DELEGATED DECISION TO DETERMINE PLANNING APPLICATIONS

Reference No:	2026/62/91032/W
Site Address:	20, Rowley Hill, Common End Lane, Lepton, Huddersfield, HD8 0JF
Description:	Erection of first floor side extension incorporating dormer window and associated alterations
Recommending Officer:	Faiza Bano

Officer Report – 2026/90752

E2 Proposed East Elevation
1 : 100

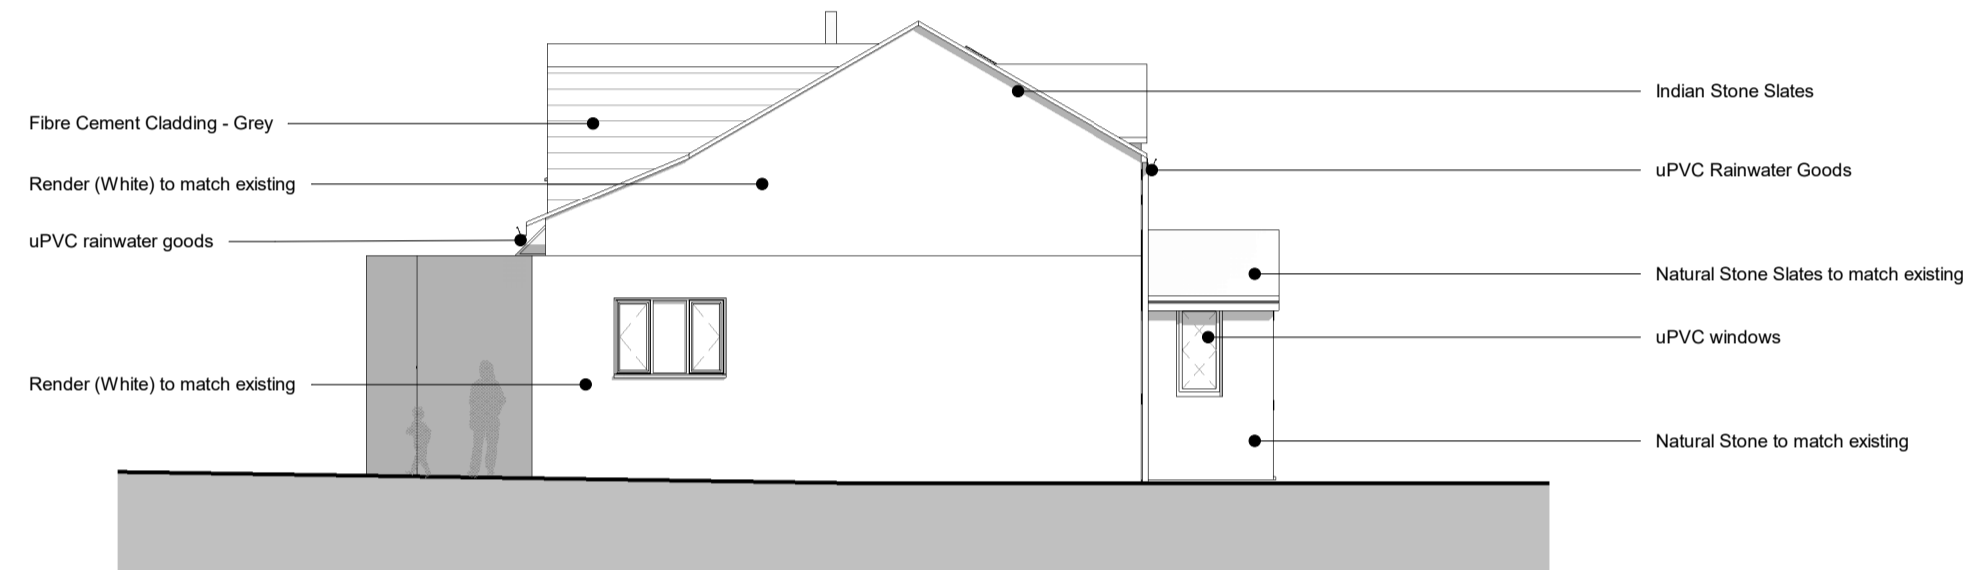
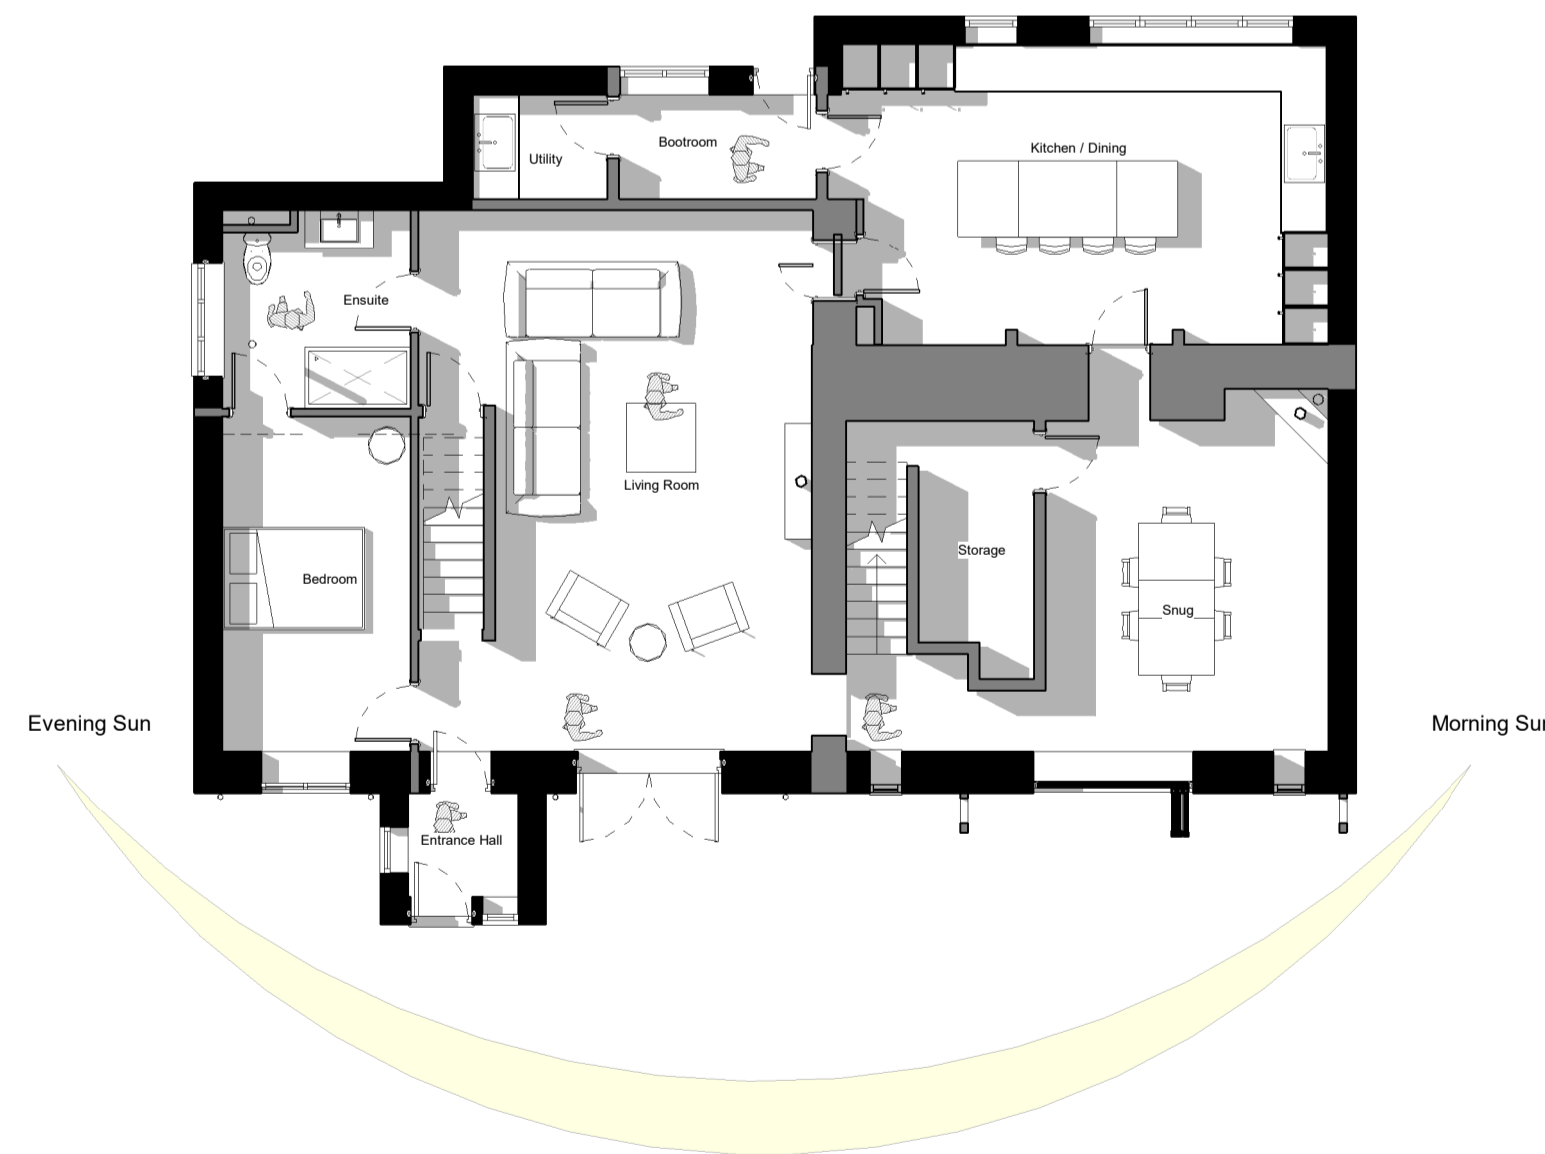
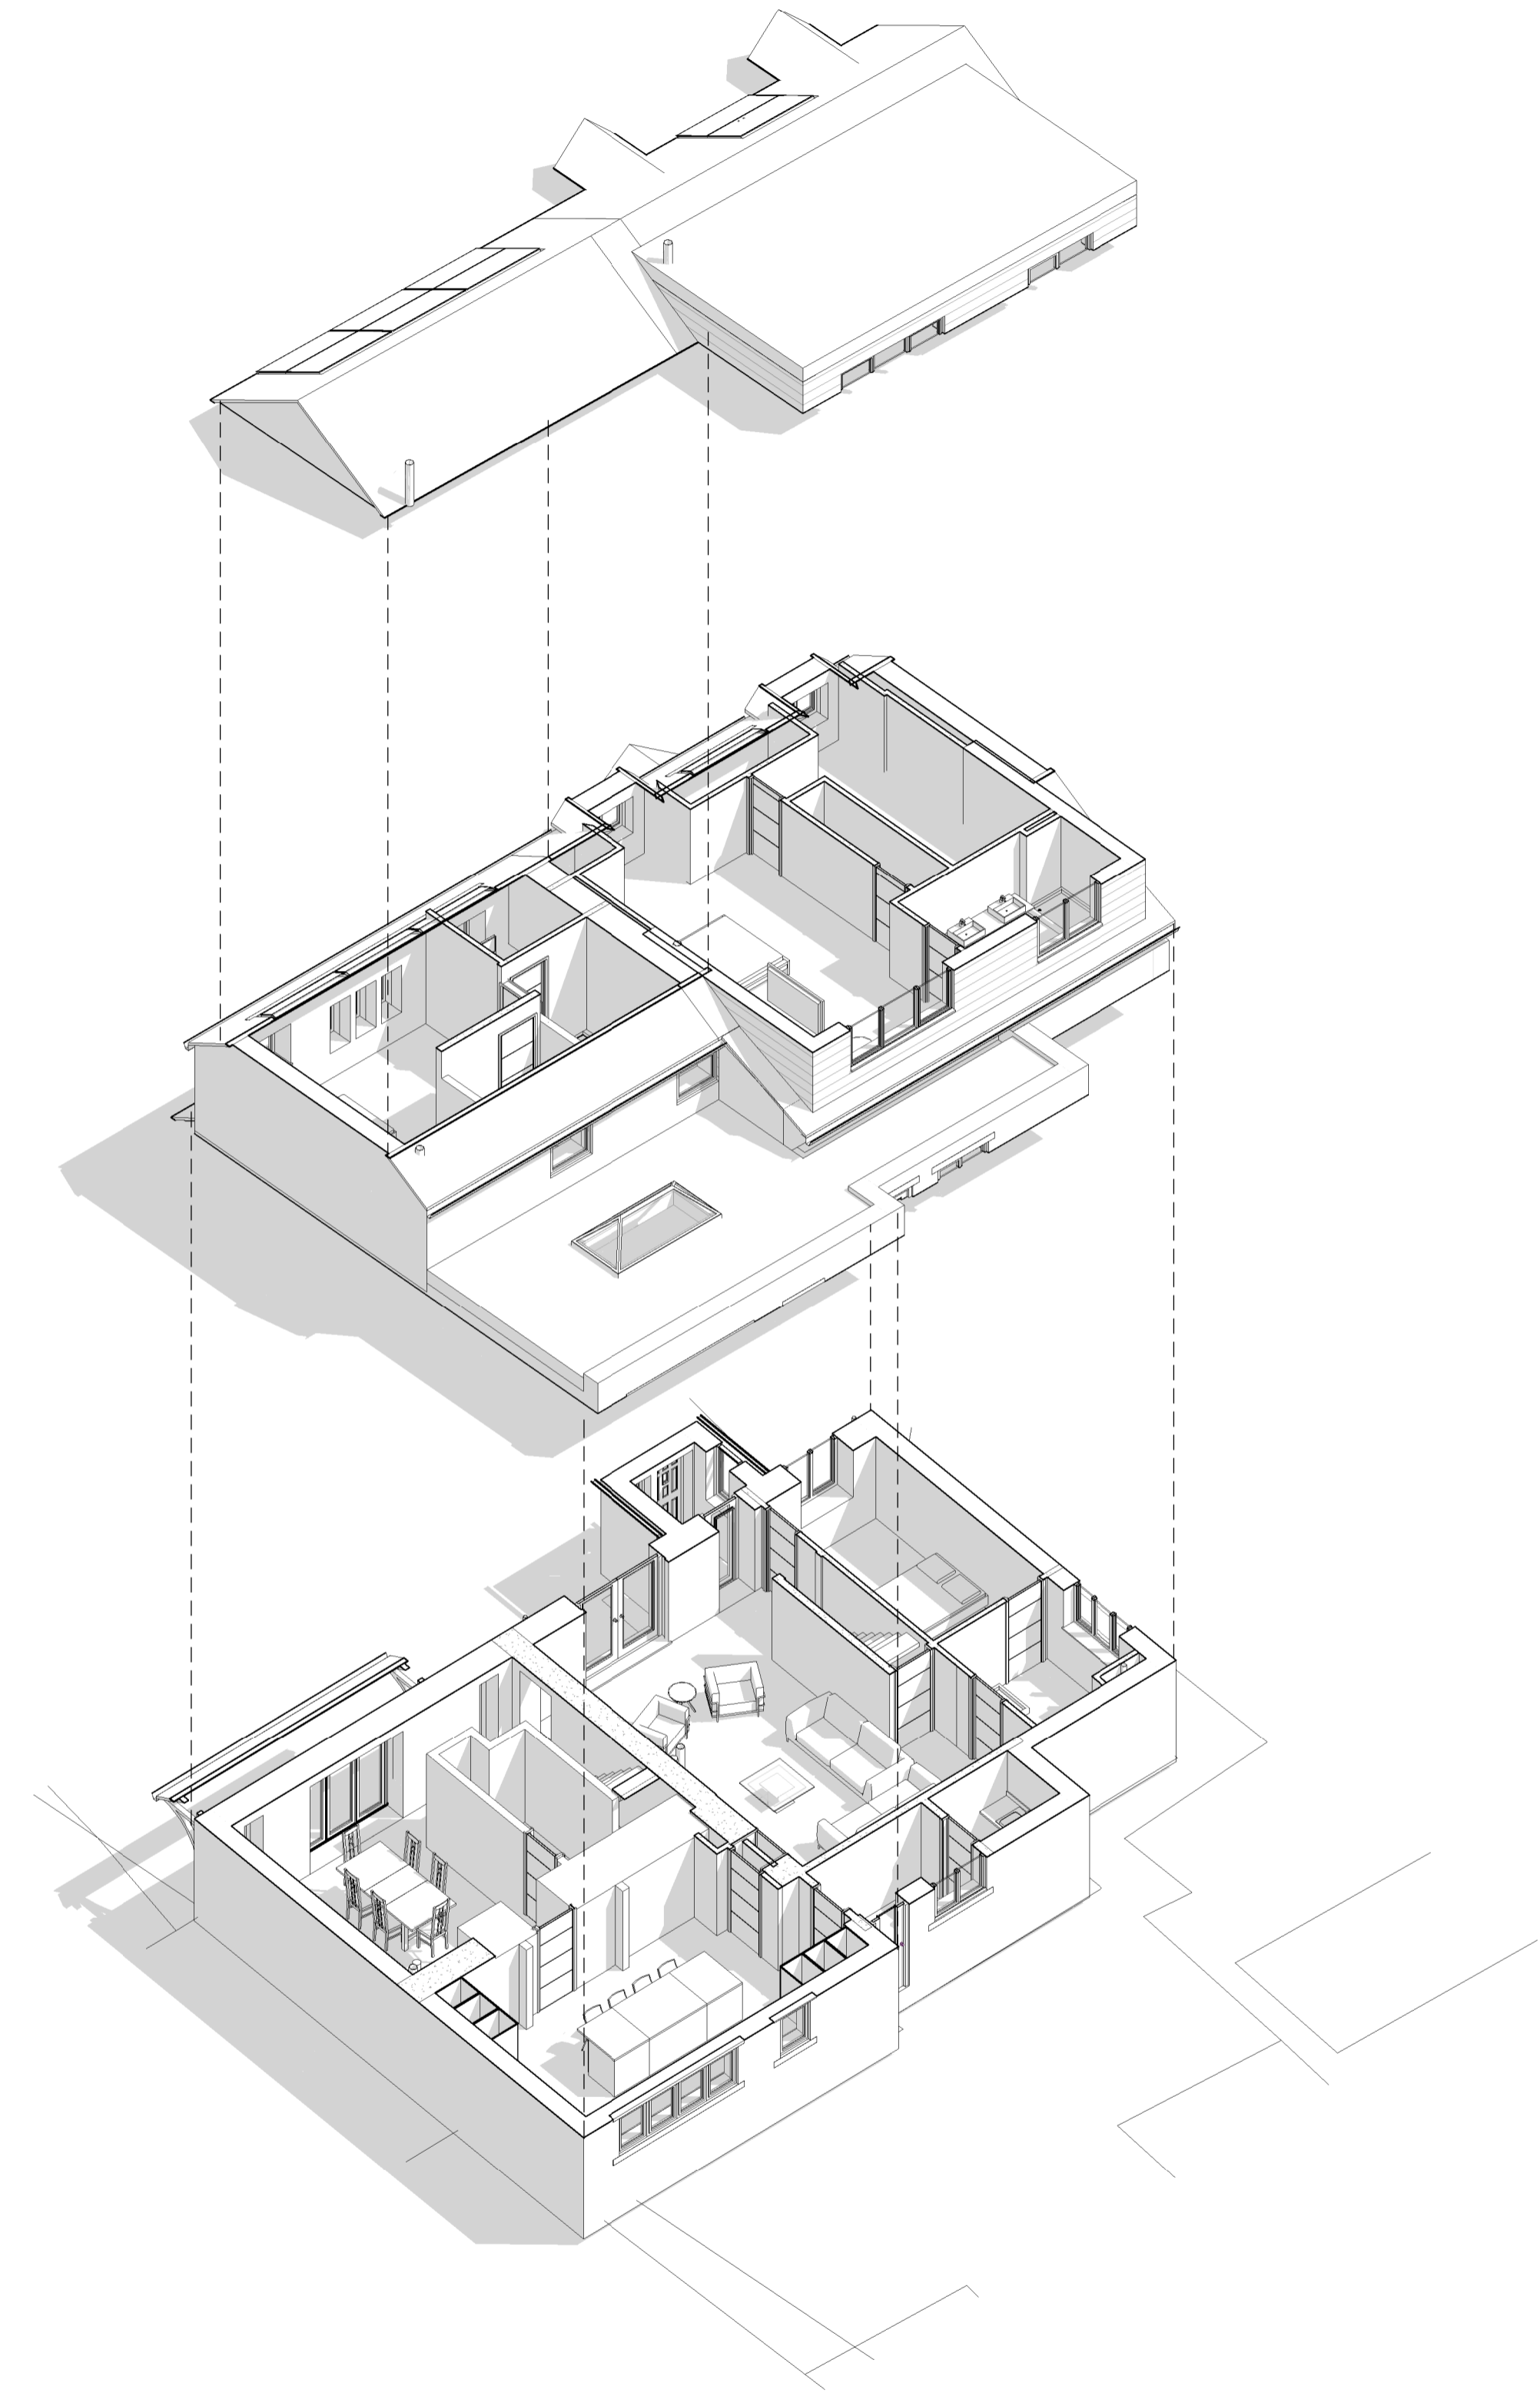
Amended plans were requested to change the design of the rear dormer. These were received, which were considered to address officers initial concerns.

The proposed dormers would be located on the rear roof slope where they would have limited visibility from the public realm. Given their position, scale and relationship with the existing roof form, they would not appear dominant or visually intrusive and would not detract from the appearance of the dwelling. Furthermore, the dormers would be read within the context of the enlarged roofscape and would preserve the overall character of the building.

The proposed dormers would be located within the rear roof slope and would principally afford views over the applicant's own rear garden and the wider area. The proposal does not introduce any unusual or unacceptable overlooking beyond that typically associated with first-floor residential accommodation. Furthermore, the extension is contained within the established built form of the property and would not result in a level of massing that would appear overbearing or oppressive when viewed from neighbouring land.
